Subject: **Outline planning application for land at Ford Airfield**

Reference: F/4/20/OUT

Objection and Comments from A J Lovell MSc. C.Eng. FICE, FICHT (retd.) - 18/12/20

FIGURE 24. KEY PRINCIPLES PLAN: VEHICULAR MOVEMENT

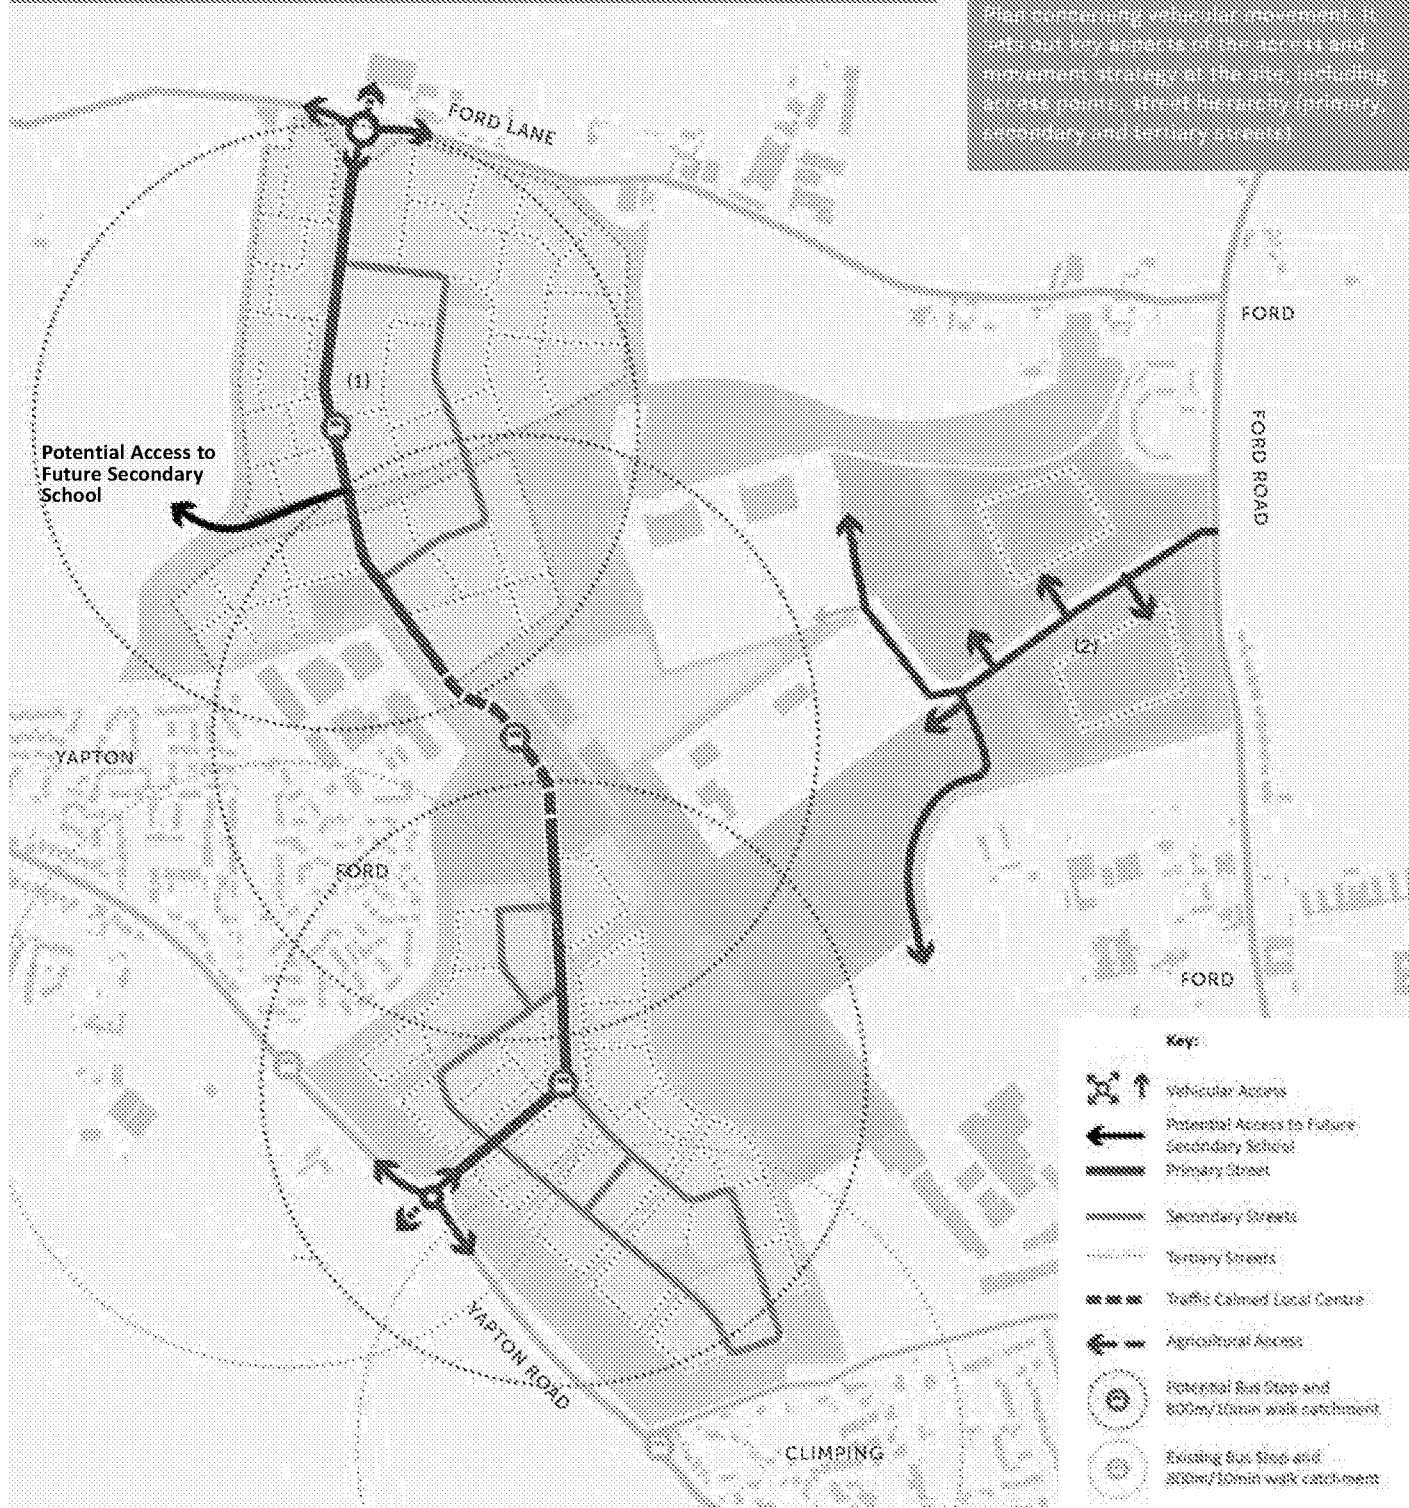
The submitted scheme proposes two access point with a new roundabout junction at Yapton Road and another at Ford Road. From these two points all traffic to and from the site will travel along Yapton Road and Ford Road (connecting to Church Lane). Traffic travelling to the south to use the A259 (which I would judge to be the majority) will have to use either the priority Oystercatcher junction or the roundabout at Church Lane, merging with all the traffic to and from the Rudford industrial estate.

It is regrettable that notwithstanding a number of approaches made in recent years the developer has not included provision for a possible future North – South route within the master plan. If the site layout is constructed as presently shown it would rule out what is potentially the saving grace for traffic movements within this whole area; a new link road between A259 and the A27, thus providing a far better alternative link to the A27 than either Yapton Road or Ford Road for all traffic, including the many HGVs from the commercial activities at Rudford and elsewhere.

2. The proposed layout will effectively prevent the construction of a new North – South route between the A259 and the A27 which is the only real solution to resolving a whole range of local traffic and safety problems in the longer term.
